Re: Application ID: 2013-058 120 Veranda Street

We are in receipt of the staff comments relating to the Level 3 Development Review Application and have the following responses:

Comments Submitted by: Shukria Wiar/Planning on 3/21/2013

PRE & POST DEVELOPMENT DRAINAGE
 PROPOSED SUBDIVISION
 120 VERANDA STREET
 OWNER: STEVEN E. & ROBERTA S. COPE
 172 CONCORD STREET
 PORTLAND, MAINE 04103

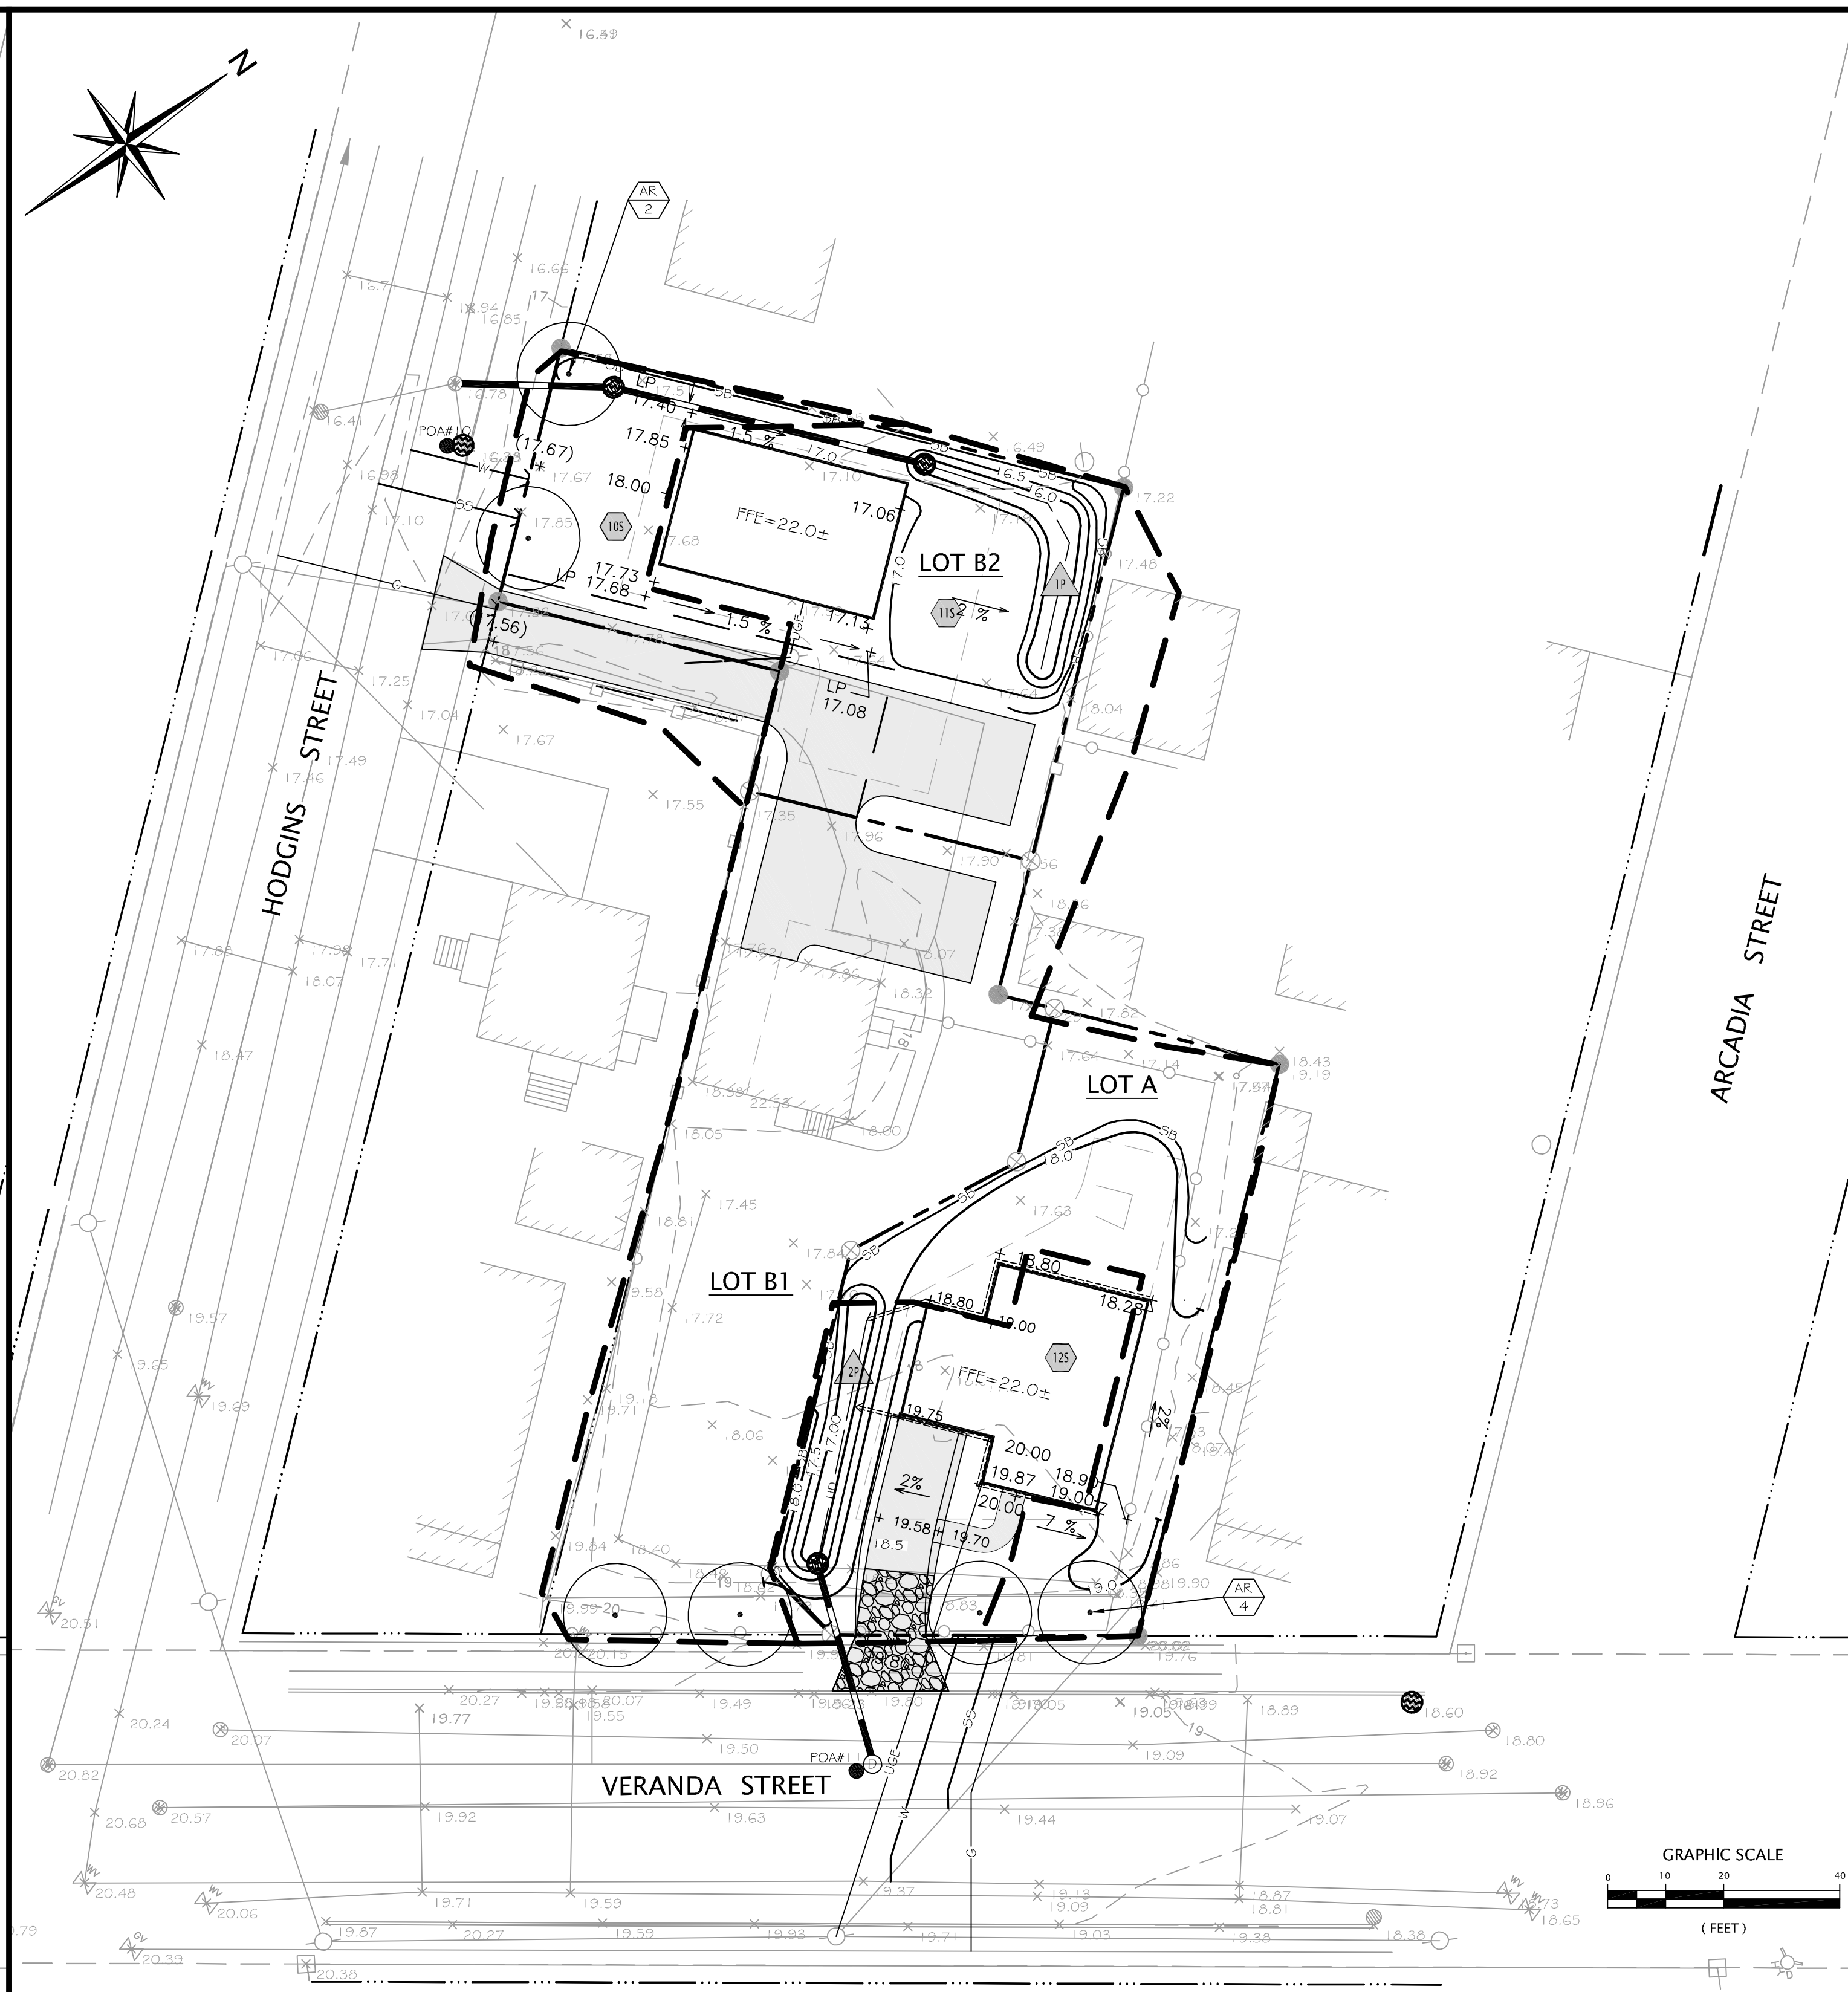
c) *Flooding Standards: The Flooding Standard requires that the Applicant demonstrate that the peak stormwater flow rate from the project site does not exceed the peak flow rate prior to undertaking the project for the 2-, 10-, and 25-year storm events. At this time, the Applicant has only submitted documentation for the 2-year storm event. The Applicant should submit appropriate documentation demonstrating compliance with the Flooding Standard (i.e. - complete HydroCAD Report for the 2-, 10-, and 25-year storm events). If the project requires a waiver from the Flooding Standard, the Applicant should include a formal request for a waiver, citing the reason for requesting the waiver and an engineering rationale for why the waiver should be granted (e.g. – municipal drainage capacity).*

Response: Additional stormwater calculations for the 10 and 25 yr storm events are attached.
